# Rezoning Transportation Analysis

Petition Number: 2021-160

General Location Identifier: 22348101

RZ - 2

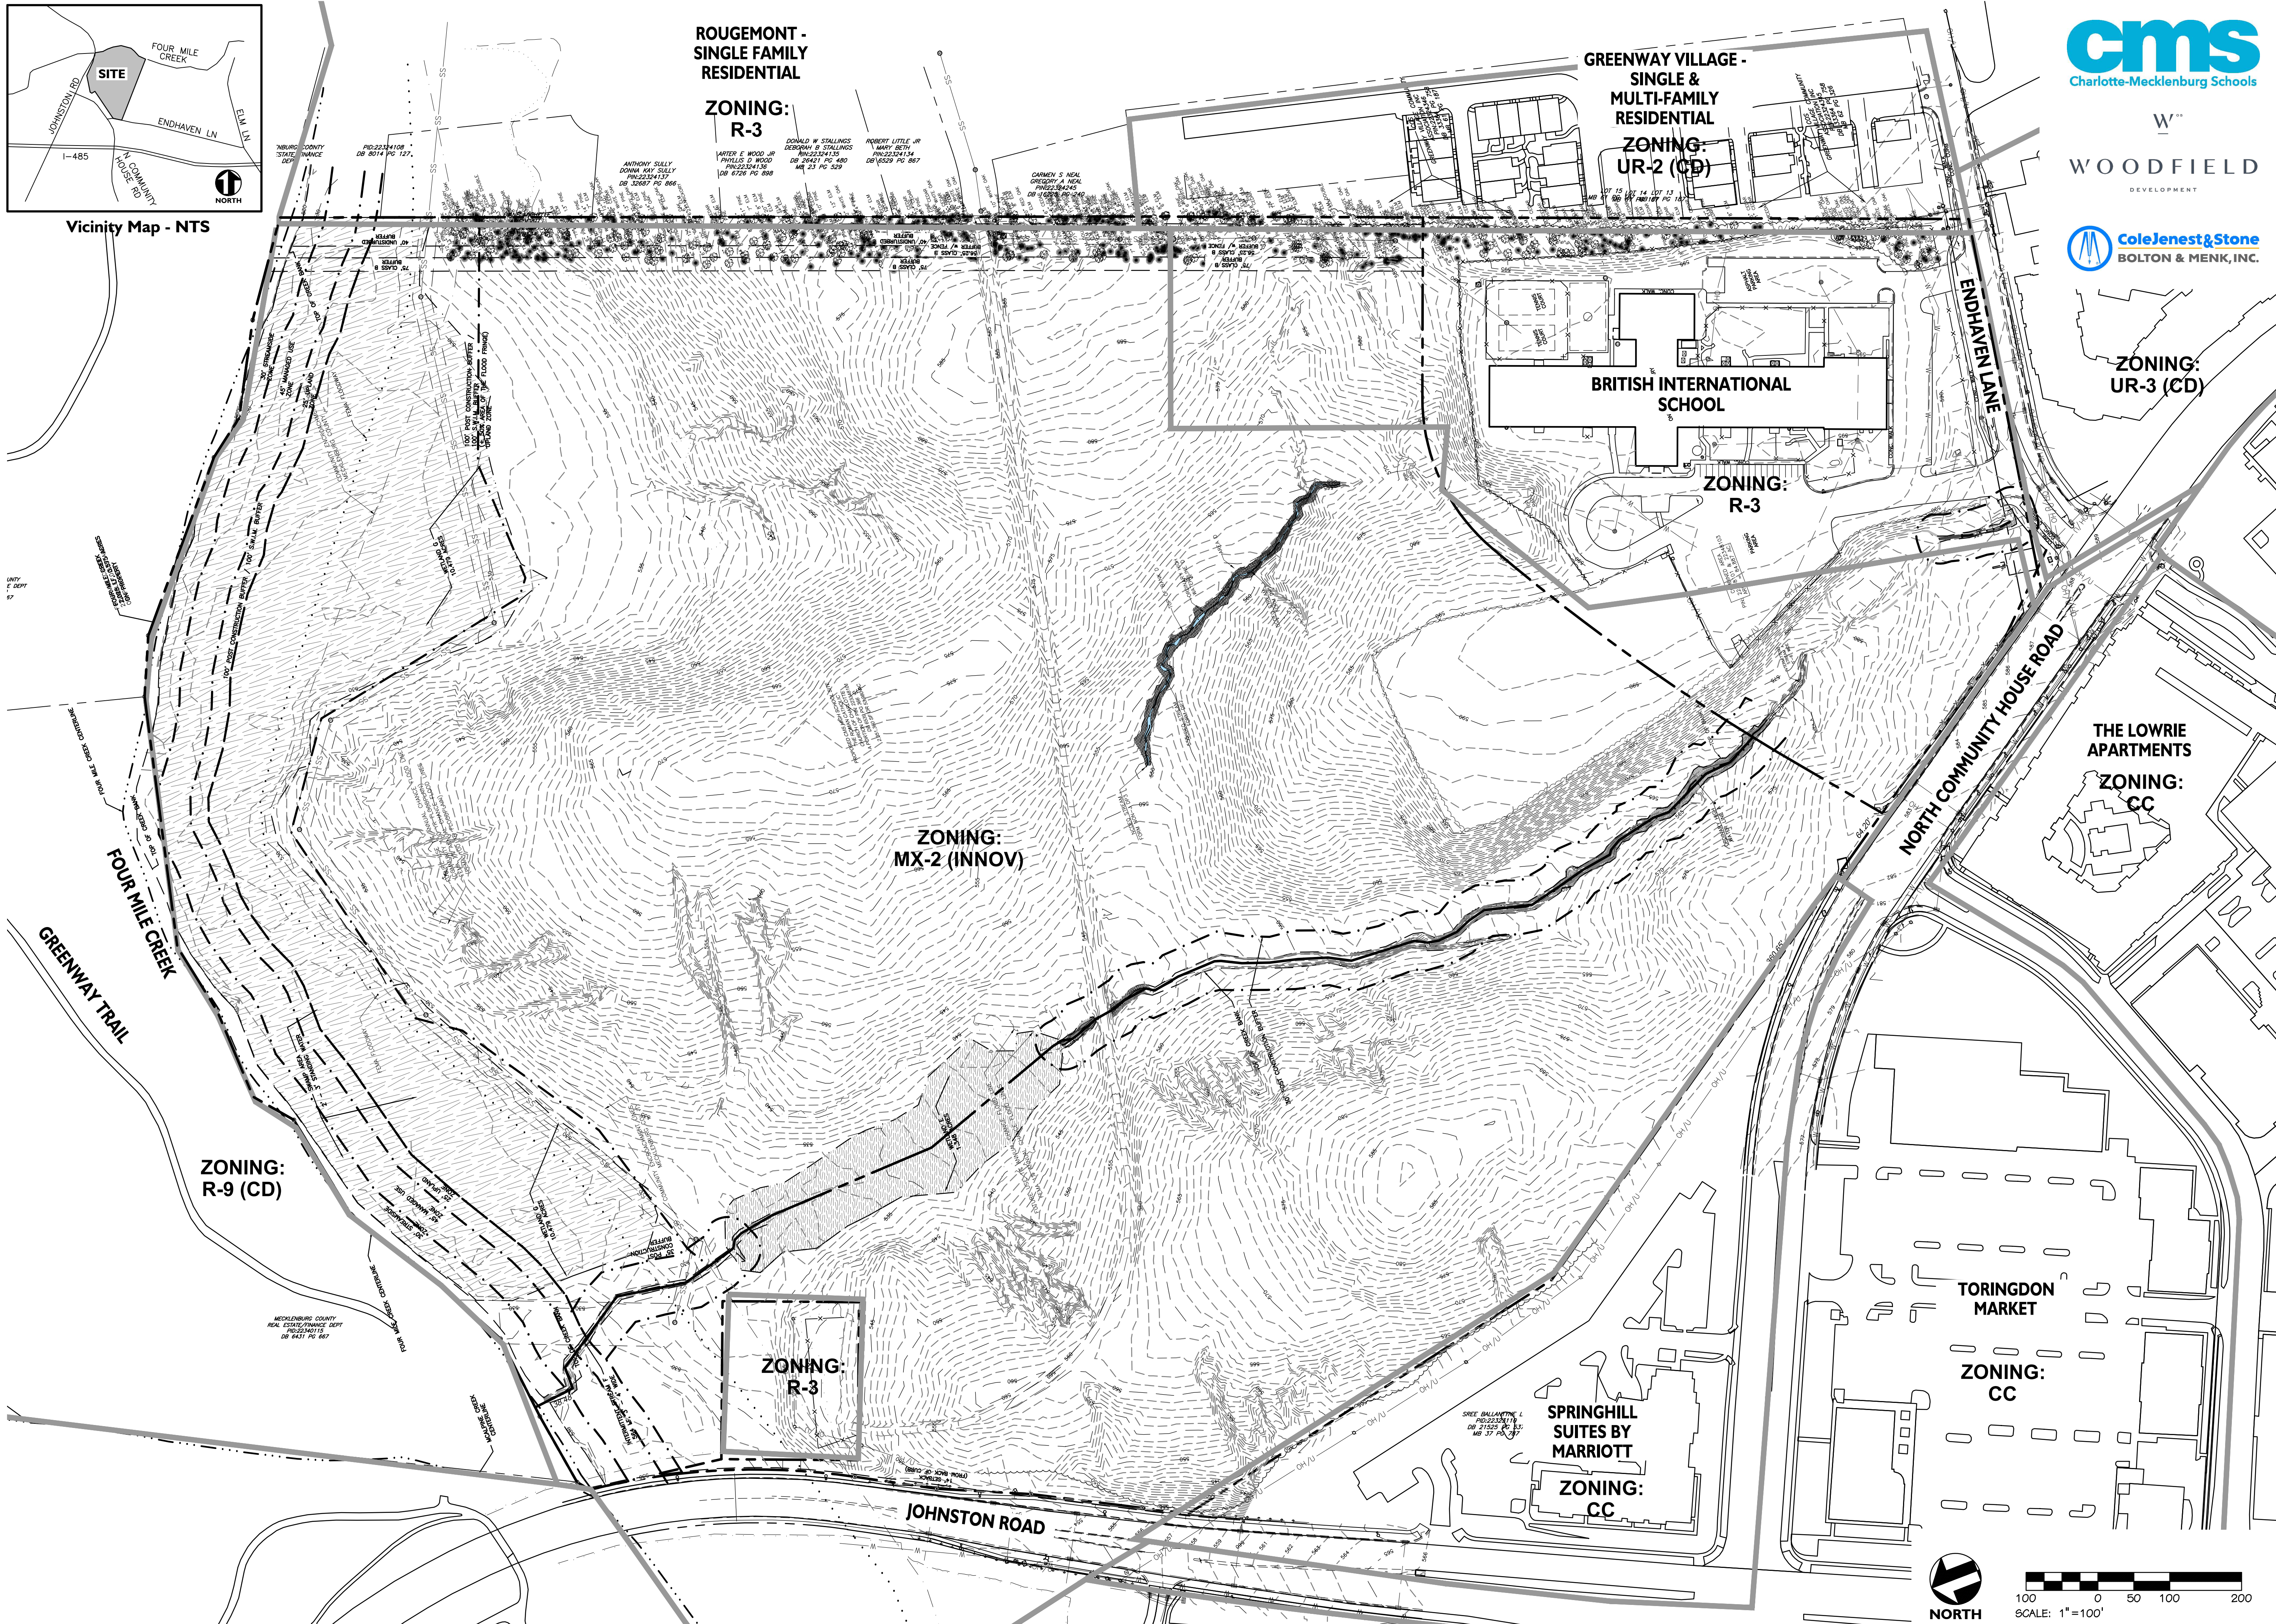
Revise site plan and conditional note(s) to commit to installing accessible curb ramps at every intersection per PROWAG and ADA law. The site plan shall label and dimension both items from the back of curb and gutter and road centerline.

- New Comment (based on Site Plan dated 10-11-2021)**  
Site plan and conditional note(s) revisions are needed to commit to construct bicycle facilities by installing a 12' multi-use path with an 8' planting strip along the site's Johnston Road frontage to meet the City of Charlotte BIKES Policy.

- Clarifying comment (based on Site Plan dated 10-11-2021):** Revise site plan and conditional note(s) to identify, depict, label, dimension, and itemize all proposed transportation-related infrastructure improvements. The conditional notes should include commitments to fully construct and fund all TIS-recommended and ordinance-required transportation improvements with applicable phasing and funding sources identified. **Specify the transportation improvements necessary to access the school as mentioned in Transportation Note #8.**

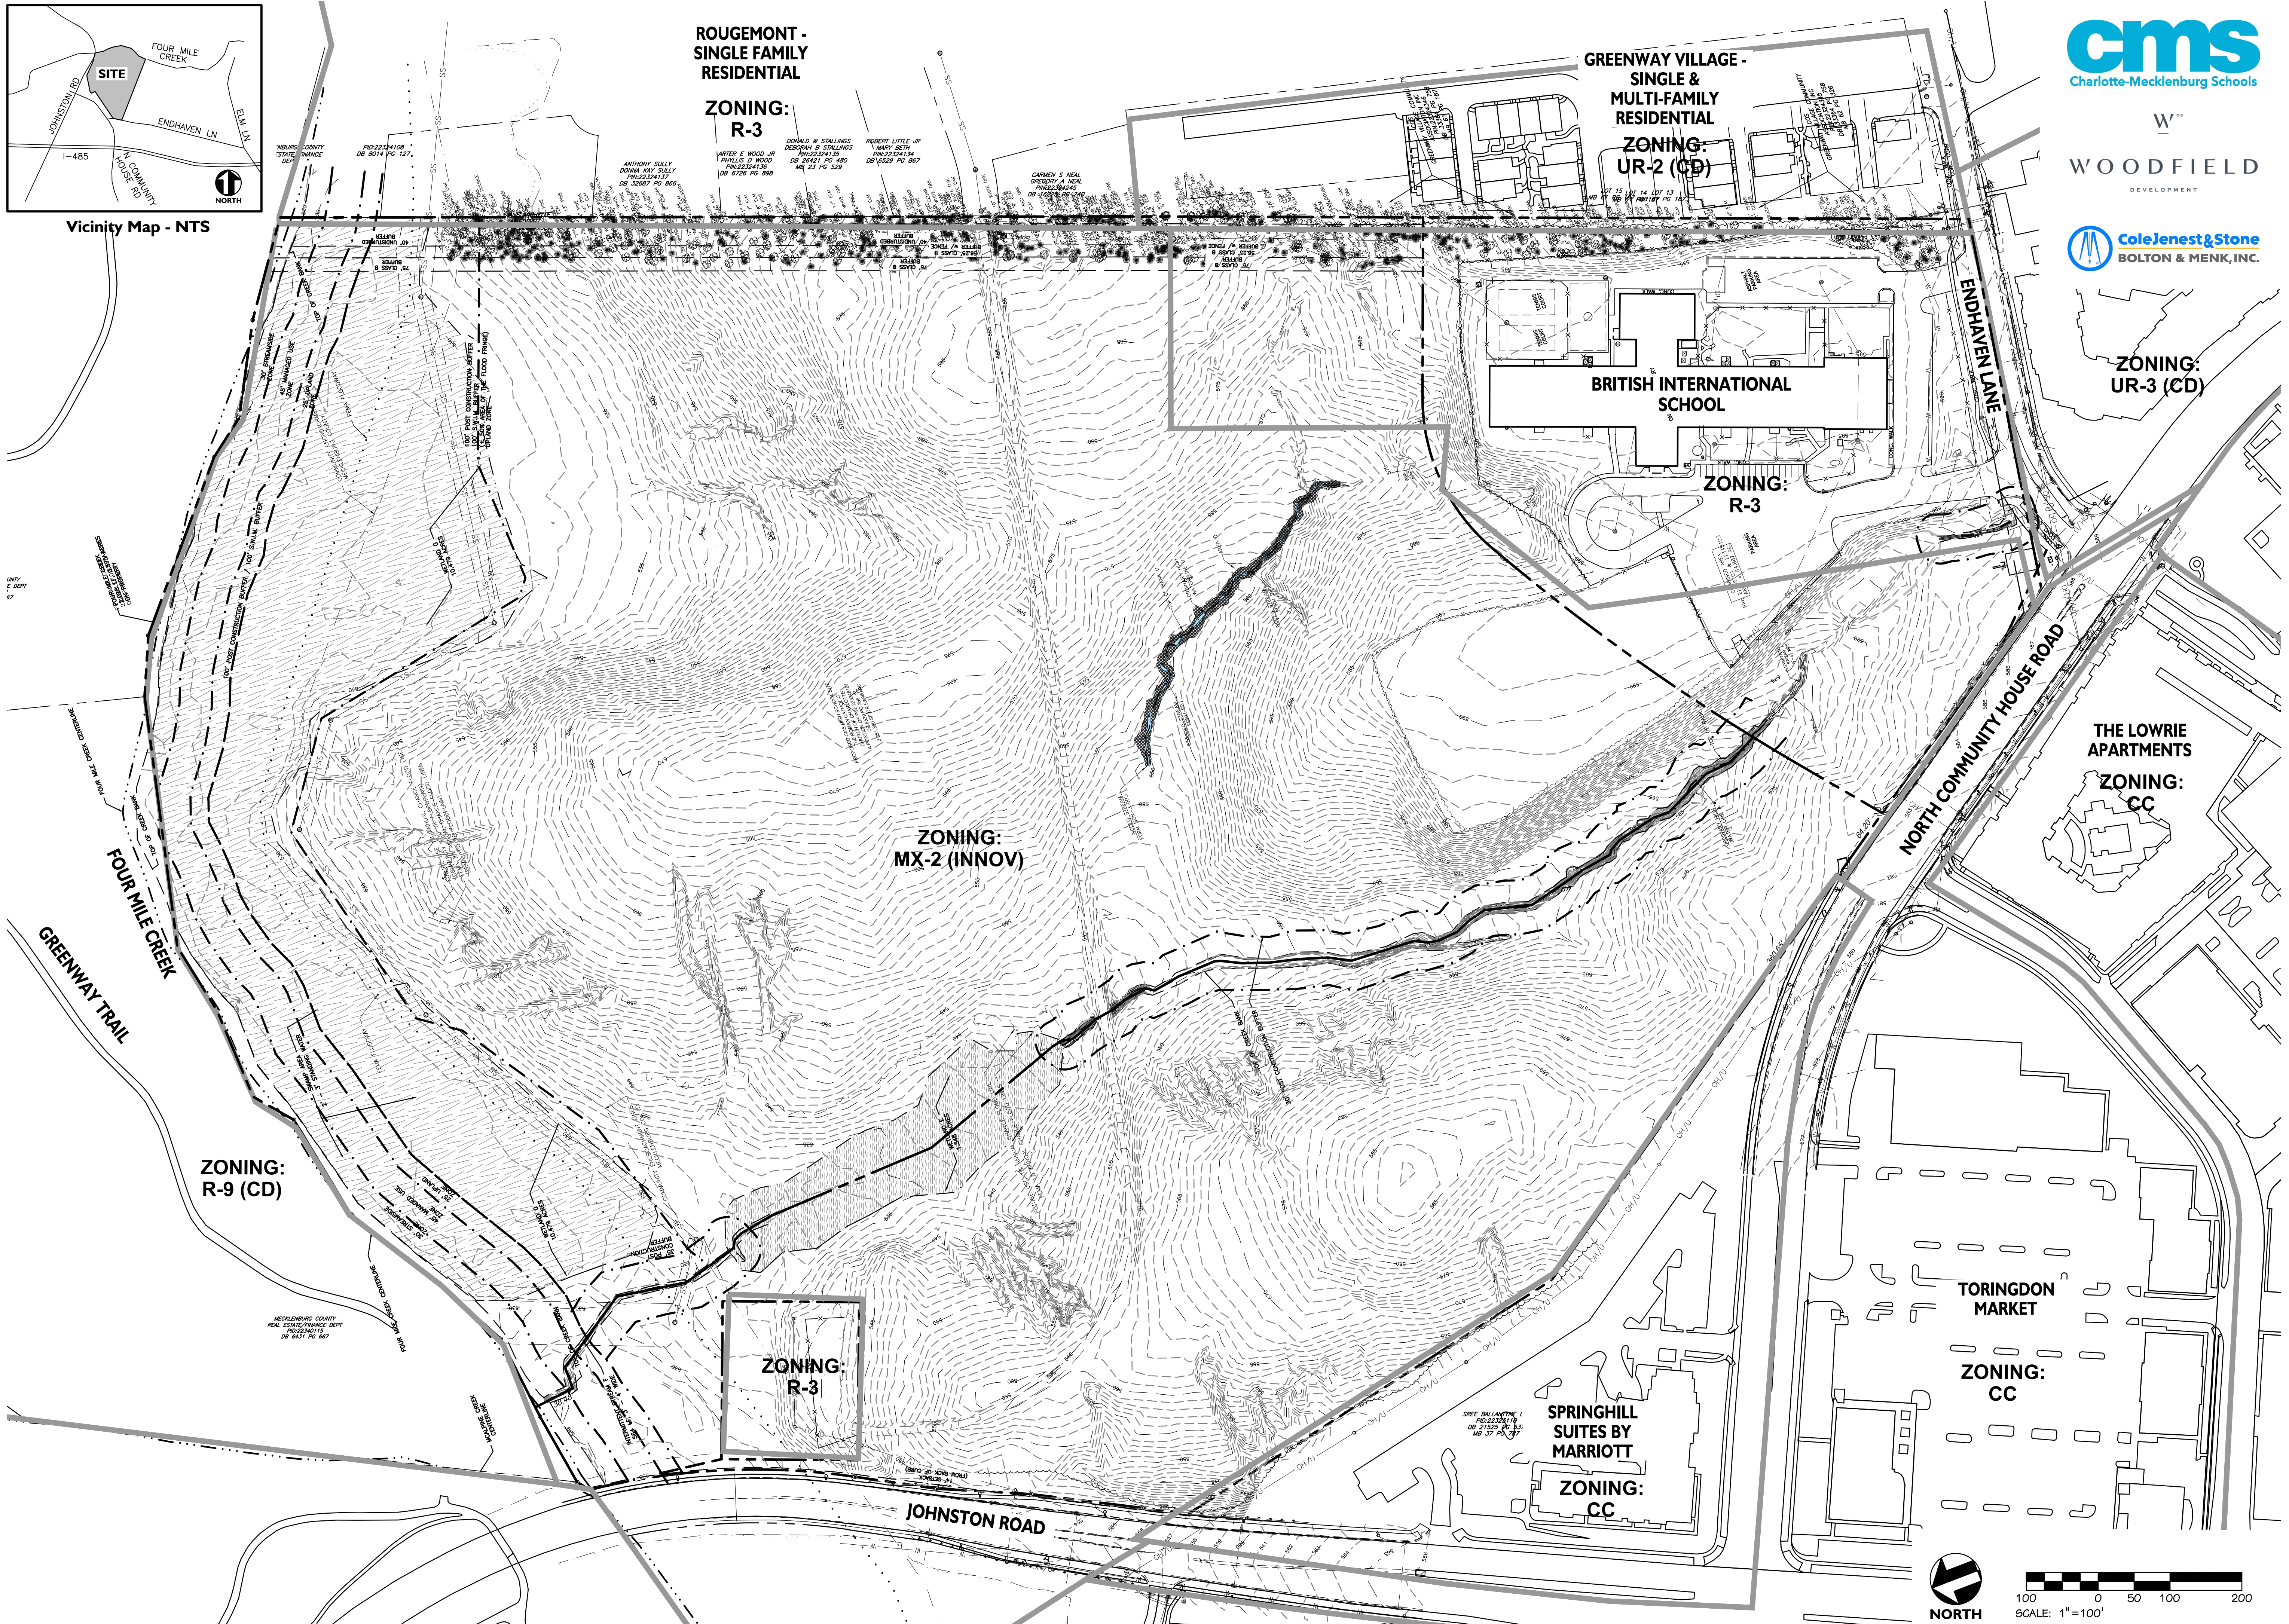
8. **New Comment** (based on Site Plan dated 12-13-2021)

Remove "on site roundabout and roadway along the school frontage" from Transportation Note #7

<p>⚠ 7. Unless stated otherwise herein, the Petitioner(s) shall ensure that all transportation improvements are substantially completed prior to the issuance of the first building certificate of occupancy for the development area for which the transportation improvement(s) relates to. Identified transportation improvements necessary to access the school shall be completed prior to the school being placed in operation. This shall include the entrance from N. Community House Rd, improvements at the intersection of Torrington and on N. Community House Rd, proposed signal, <del>on site roundabout and roadway along the school frontage.</del> ⚠</p>
--
